Ár dTag|Our Ref. TII22-119629

Do dTag|Your Ref. NA29S.314232

Re: **DART+ West Electrified Railway Order 2022**

Transport Infrastructure Ireland (TII) acknowledges receipt of referral of the DART+ West Railway Order application (Dublin City to Maynooth and M3 Parkway) by Córas Iompair Éireann.

Client		
Project		
Drawn By	LA	Checked By
Scale	1:1250 (@A0)	Date
Area No.	011	Plan No.
Approved By	MH	Works Layout Plan No.
		WP011

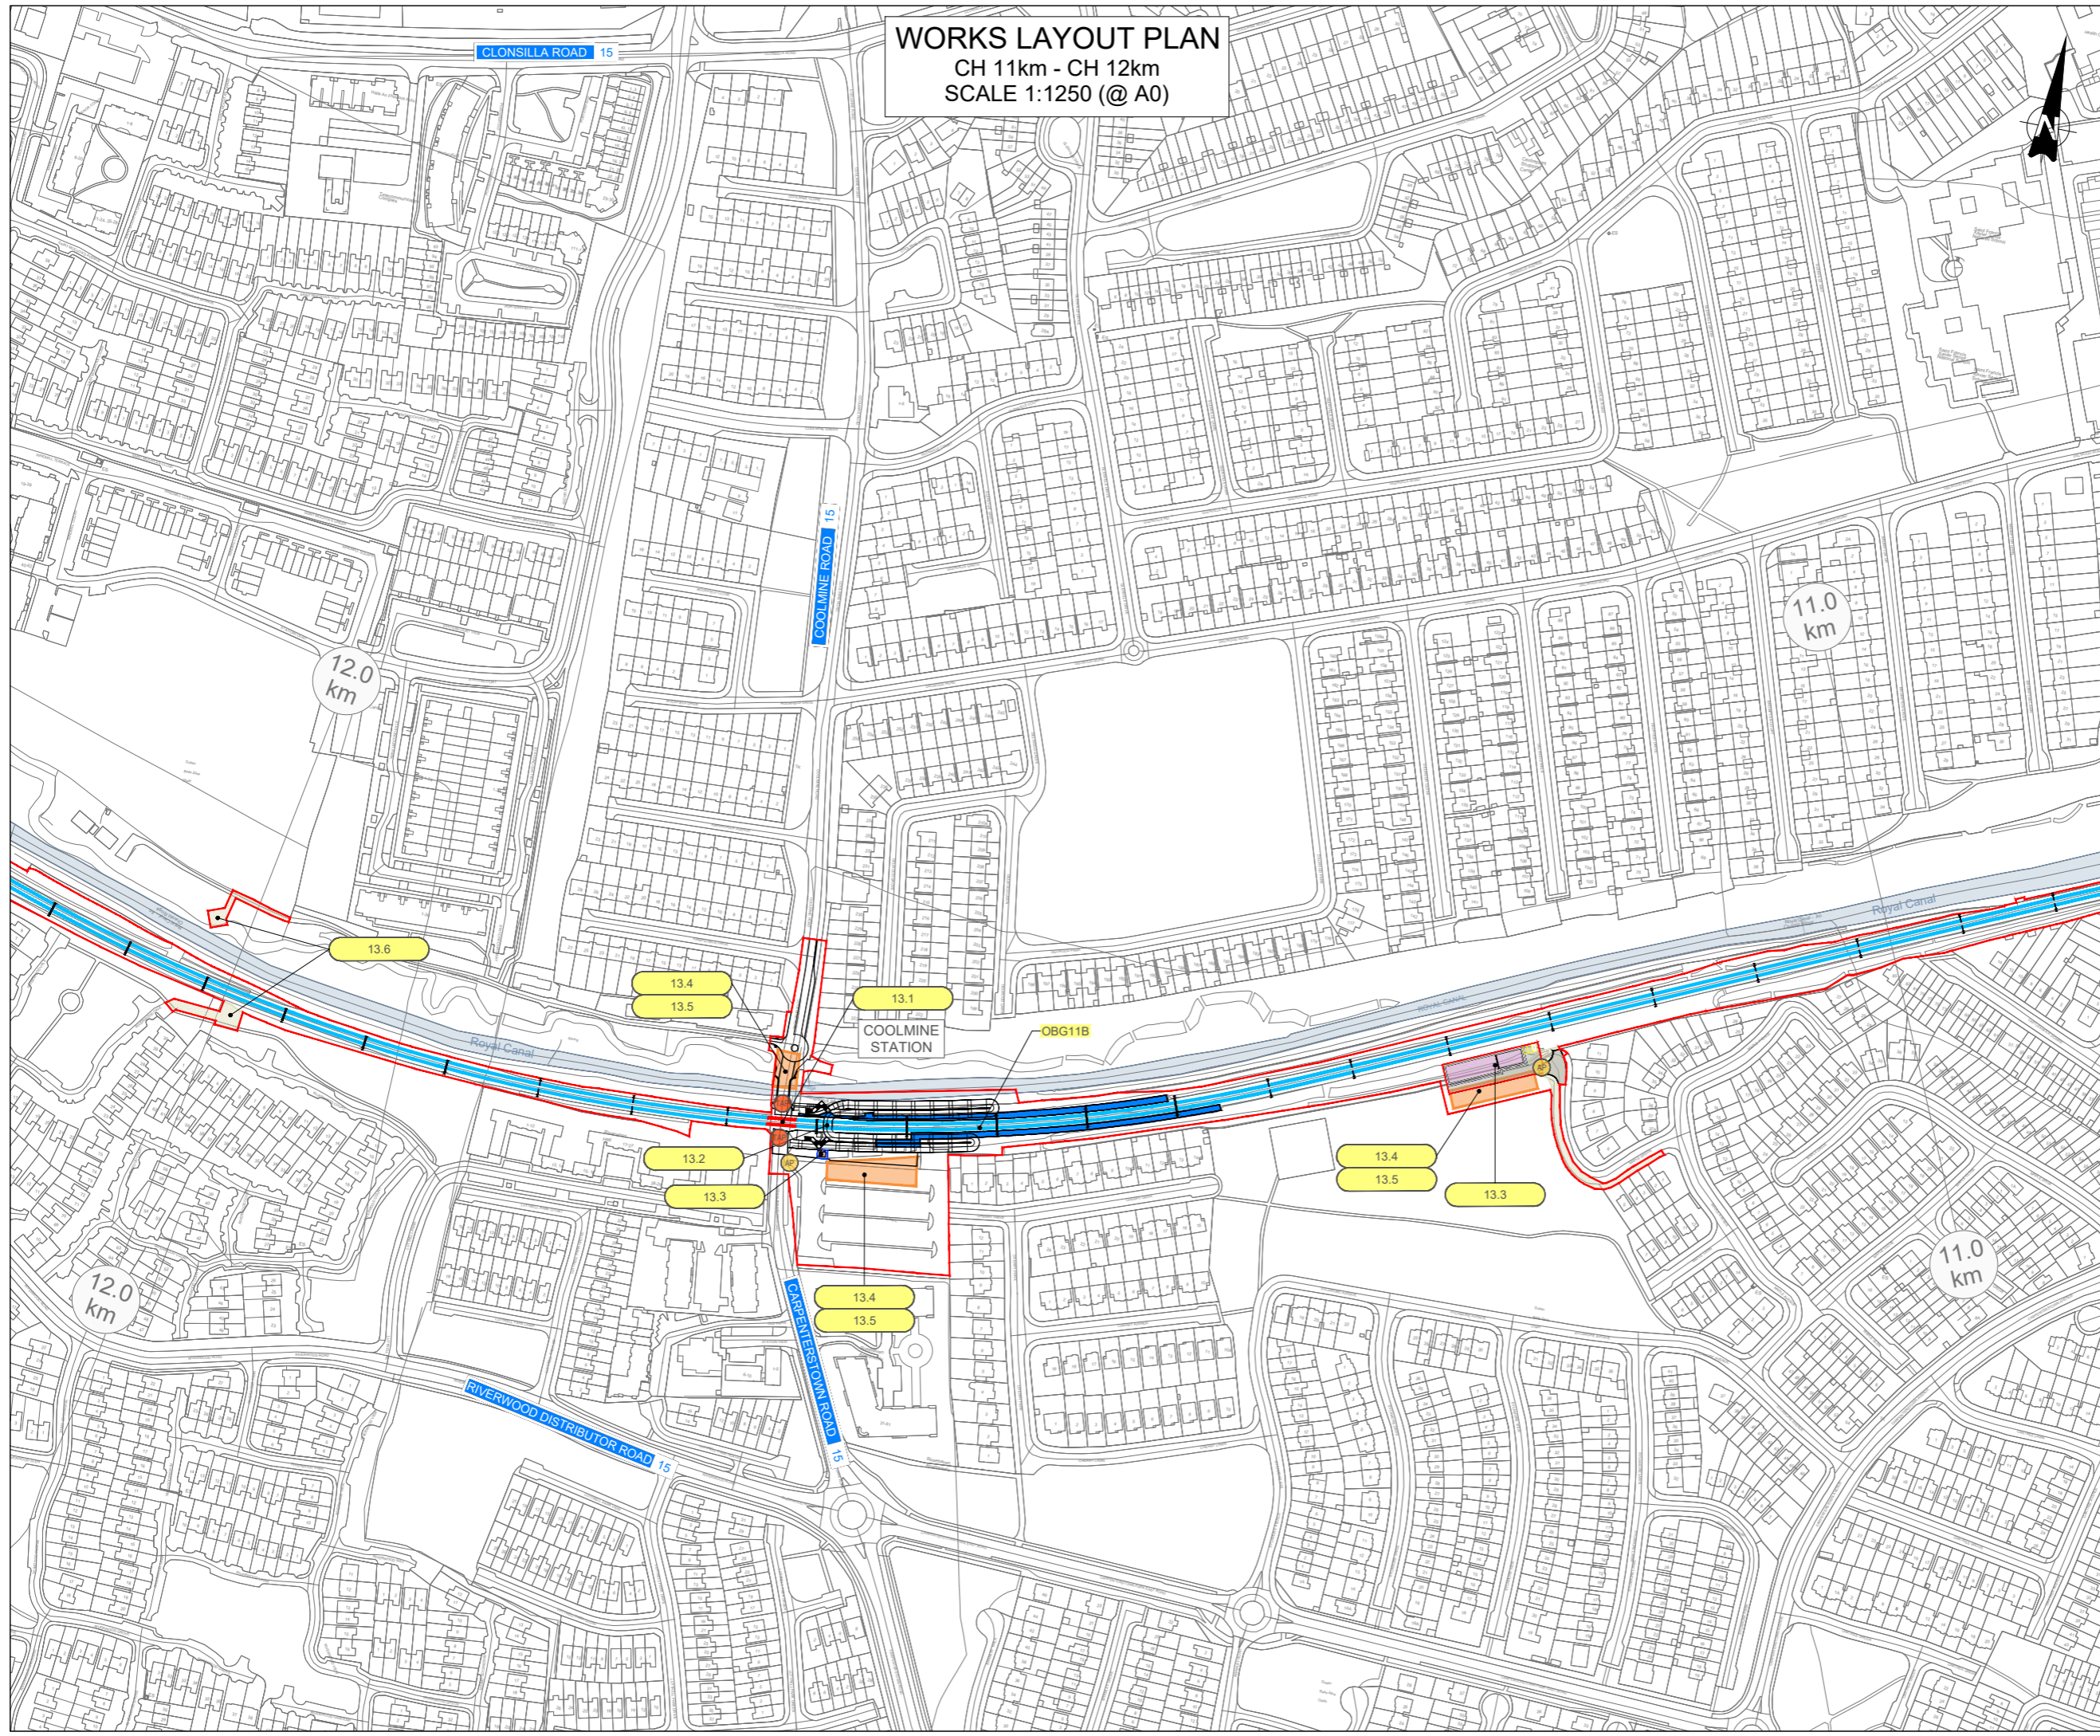
Book 1 of the Railway Order Drawings contains *Works Layout Plan No. WP011* that indicates proposed works along the railway line that crosses Junction 6 of the M50 the most heavily trafficked national primary national route. Junction 6 of the M50 is a critical interchange with another national primary route the N/M3.

- The N3 utilises the bridge identified as OBG6C on Works Layout Plan No. WP011
- The N3 and M50 utilise the bridge identified as OBG6D on Works Layout Plan No. WP011
- The M50 roundabout utilises the bridge identified as OBG7A on Works Layout Plan No. WP011
- The M50 runs under the dedicated railway bridge identified as OBG7B on Works Layout Plan No. WP011
- The M50 roundabout utilises the bridge identified as OBG7C on Works Layout Plan No. WP011

As noted above, the structures on the N3 and M50 roundabout that are part of the proposed works occur within a MMaRC maintained area (OGB6C, OGB6D, OGB7A, and OGB7C). The dedicated railway bridge OGB7B runs over the M50 which is subject to a PPP maintenance contract over the area of the national road reservation. Consultation with the Motorway Maintenance and Renewals Contract Network A and PPP Contractors is required, via Transport Infrastructure Ireland (TII), in relation to any works proposed that affect the motorway and national roads and associated junctions in terms of operational requirements such as timetabling.

It is noted that the majority of the works to the railway line at Junction 6 of the M50 are indicated at Book 1 of the Railway Order Drawings at *Works Layout Plan No. WP011* consist of *Proposed Railway Electrification* which indicates no vertical or horizontal alignment alterations of the railway. However, there is a section of railway running from just east of OBBG6C to the eastern side of the M50 indicated to consist of *Proposed Track Alignment Modification and Electrification*.

Schedule 1 works indicated in the immediate vicinity of Junction 6 of the M50, east to west, are nos. 11.2 and 11.3 at OBG6C; and 11.4 and 11.5 at OBG7A. There are no further Schedule 1 works indicated on *Works Layout Plan No. WP011* at the M50 Junction:-

In addition to track lowering under OBG6C, works to heighten the parapet of this bridge are described in Section 5.6.9 of the EIAR, that identifies OBG6C as the *"N3 road bridge in Blanchardstown"*. This section of the EIAR directs to section 5.3.12 *Parapets* and subsection 5.3.12.1 *Parapets on bridges*. It is noted that the construction sequence for parapets on bridges at subsection 5.3.12.1 includes works to the road pavement surface. There does not appear to be recorded an intended timeframe and co-ordination with track lowering beneath OBG6C.

It is noted that the track lowering area ends on its western side immediately adjacent to the M50 motorway.

There does not appear to be recorded an explicit indicative timeframe and intended co-ordination of drain installation with track lowering at OBG7A.

The proposed drainage arrangement for OBG7A, as a national road structure is part of the national road drainage infrastructure and designed for that purpose. The drainage proposal part of the proposed works has the potential to impact on the capacity and efficiency of the drainage regime provided for the national road network. Therefore, it is in order that the drainage design and construction management and maintenance approaches that safeguard the national road drainage infrastructure is agreed with the Network Management section of TII in consultation with the MMarC contractor prior to commencement of development.

The proposed railway order works, at Junction 6 of the M50 have the potential to impact the national road network, including structures (ONBG6C, OBG6D, OBG7A, OBG7B, and OBG7C) on that network and requires prior consultation with TII and compliance with standards in TII publications.

In this regard, it is noted that at 5.3 *Project Wide Construction Works and Methodologies*, subsection 5.3.1 *Surveys and licences* in *Chapter 05 Construction Strategy* of the submitted EIAR does not appear to record the requirement to comply with TII Publications standards for the national road network, including structures and services. In turn, *Chapter 05 Construction Strategy* and *Chapter 27 Mitigation and Monitoring Measures* of the submitted EIAR do not appear to identify specific methods or techniques proposed for mitigation of potential impact for works traversing or in proximity to the national road network.

- Compliance with TII Publications (Standards) in accordance with relevant TII Publications (Technical) will be required for any work that may impact the national road pavement, structures and infrastructure including drainage. In particular, Design Reports will be required to be prepared and submitted as a Departure Application in accordance with TII publication GE-GEN-01005 and PE-PMG-02041 and any works to structures forming part of the national road network requires TII Technical Acceptance in accordance with TII publication DN-STR-03001.

- Access for the construction period and any subsequent monitoring and maintenance in relation to any works proposed, including temporary and permanent signage, that affect the national road and associated junctions in terms of operational requirements, timetabling, etc. will require prior consultation with the MMarC Network A and M50 PPP Contractors and fulfilment of requirements to complete their 3rd party protocols, via the relevant road authorities and TII.

- Separate structure approvals/permits and other licences may be required in connection with the proposed works, including where temporary modification to the road network may be required.

It is appropriate that specific mitigation and monitoring commitments for potential impact on the national road network at Junction 6 of the M50 are reflected in the submitted EIAR at *Chapter 05 Construction Strategy*, in the proposed CEMP at Appendix 5.1 and at *Chapter 27 Mitigation and Monitoring Measures*.
